Two storey rear extension including rendering of brickwork chimney stack & deletion of dormer on west elevation (resubmission following R/67/17/HH)

3 Bushby Avenue Rustington

Thank you for your internet representation made on 29th August 2018 which has been recorded as '**an objection**' with the comments as follows:

FIRST FLOOR PLAN

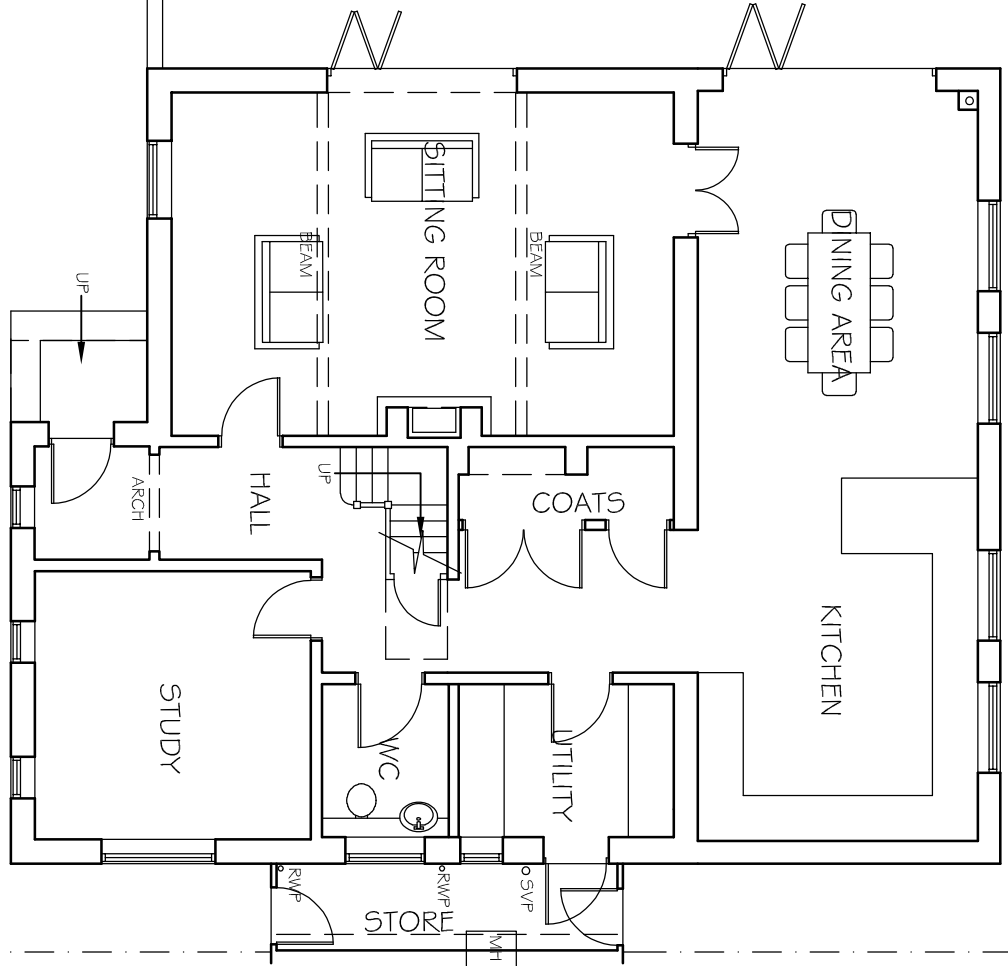
Concerning the north elevation of 3 Bushby Avenue, We object to the large double patio door on the North elevation first floor. This overlooks the south and east windows on our property and our rear garden. On the original plan this was a small bathroom window.
